# KITTITAS COUNTY FIRE MARSHAL'S OFFICE

June 30, 2010

Re: Ferrell (BL-10-00019)

Proposed BLA
around Drainfield

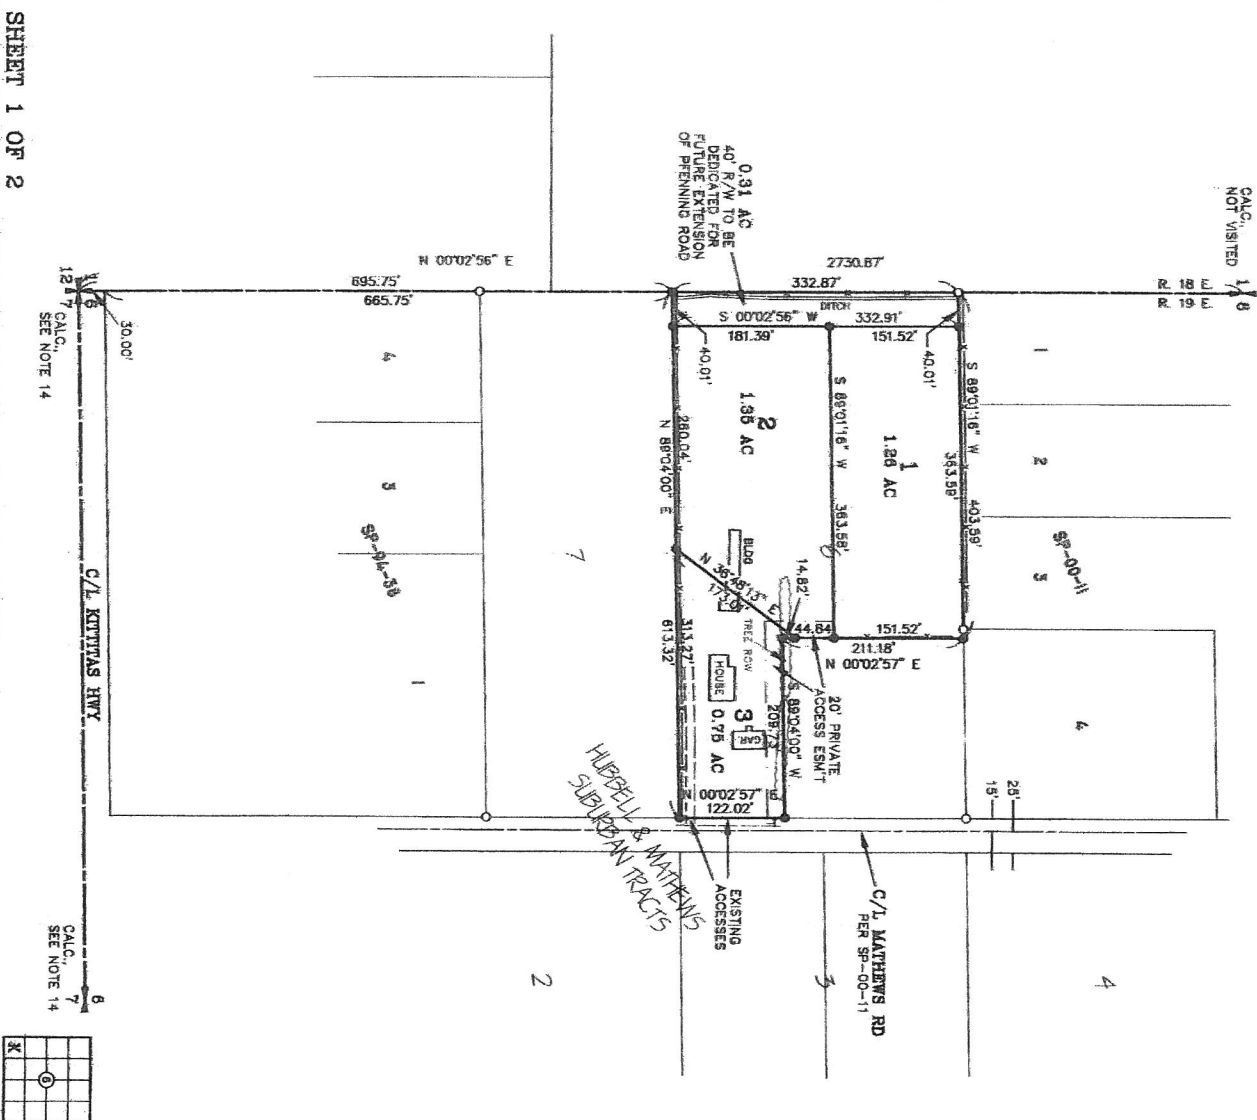
- Ensure that boundary line adjustments do not infringe upon existing structures, to include propane tanks, etc.
- All future development must comply with the International Fire Code.
